Your ref: SSD 5175 MOD5
& SSD8858
Our ref: MC 12-1769 &
MC-17-00004 &

Re: SSD 5175 MOD 5 & SSD 8858 – Bulky goods retail centre on Lot 1 at Eastern Creek Business Hub

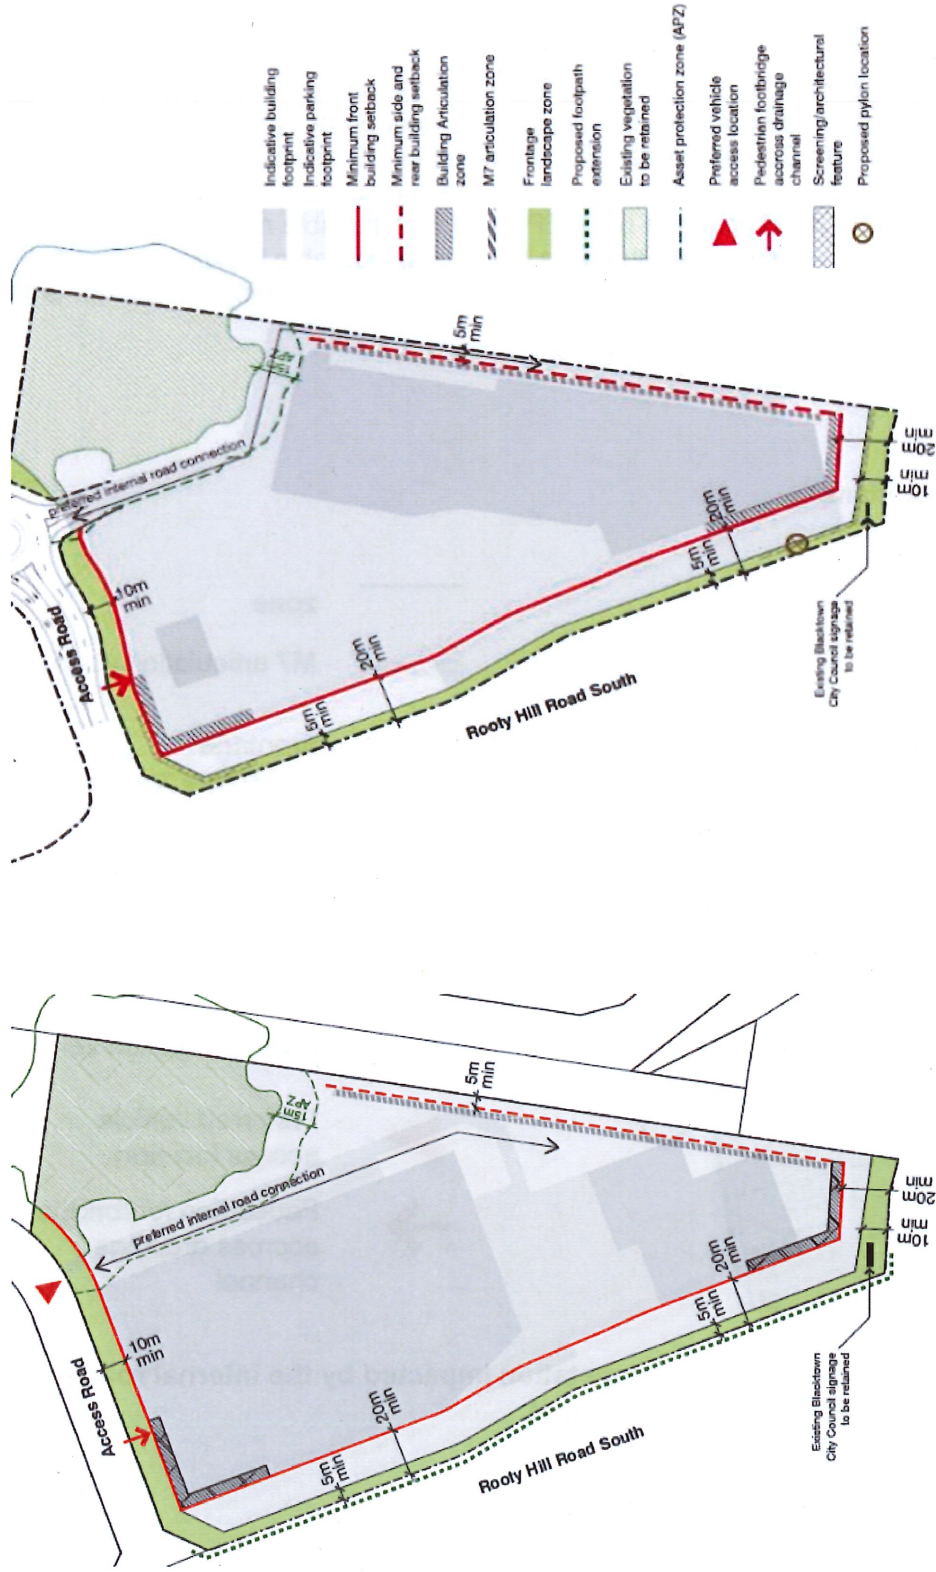
- ii. Additional traffic generated by the proposed development is likely to be accommodated within the existing and new road network capacity.
- iii. Turning diagram shows that a 19m long articulated would have difficulty to turn at the roundabout as well as along the tight bends on the proposed truck route.
